## REQUEST

Current Zoning: NS (neighborhood services), B-1(CD) (neighborhood business, conditional), and N1-A (neighborhood 1-A)  
Proposed Zoning: UR-2(CD) (urban residential, conditional)

Approximately 13.50 acres located at the northeast intersection of Albemarle Road and Novant Health Parkway, west of Cresswind Boulevard.

The petition proposes to allow up to ~~310~~ **265** multi-family residential units on acreage developed with residential homes and vacant land, located just east of the intersection of Albemarle Road and Interstate 485.

TECHNICAL DATA SHEET
FOR
PETITION # 2022-066
ALBEMARLE ROAD APARTMENTS
CHARLOTTE, NORTH CAROLINA

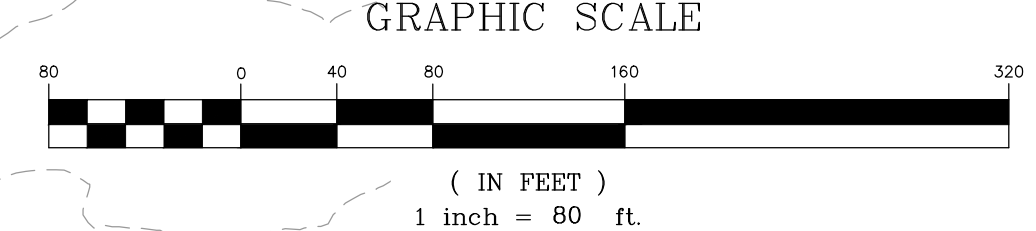
- ~~1. Revise site plan and conditional note(s) to commit to dedicate 100 feet of right-of-way or existing right-of-way, whichever is greater from the road centerline of Albemarle Road. The site plan shall label and dimension the right-of-way from the road centerline of Albemarle Road and Novant Health Parkway.~~

- ~~2. Tree save must meet all standards. Easements are not permitted in tree save areas. Remove this statement because it does not follow the ordinance.~~

- ~~3. Confirm if the clubhouse is referenced/committed to in the development notes.~~
- ~~4. Possible BMP areas are located along Novant Health Parkway. Approved plant materials should be provided so the areas serve to add to community character.~~
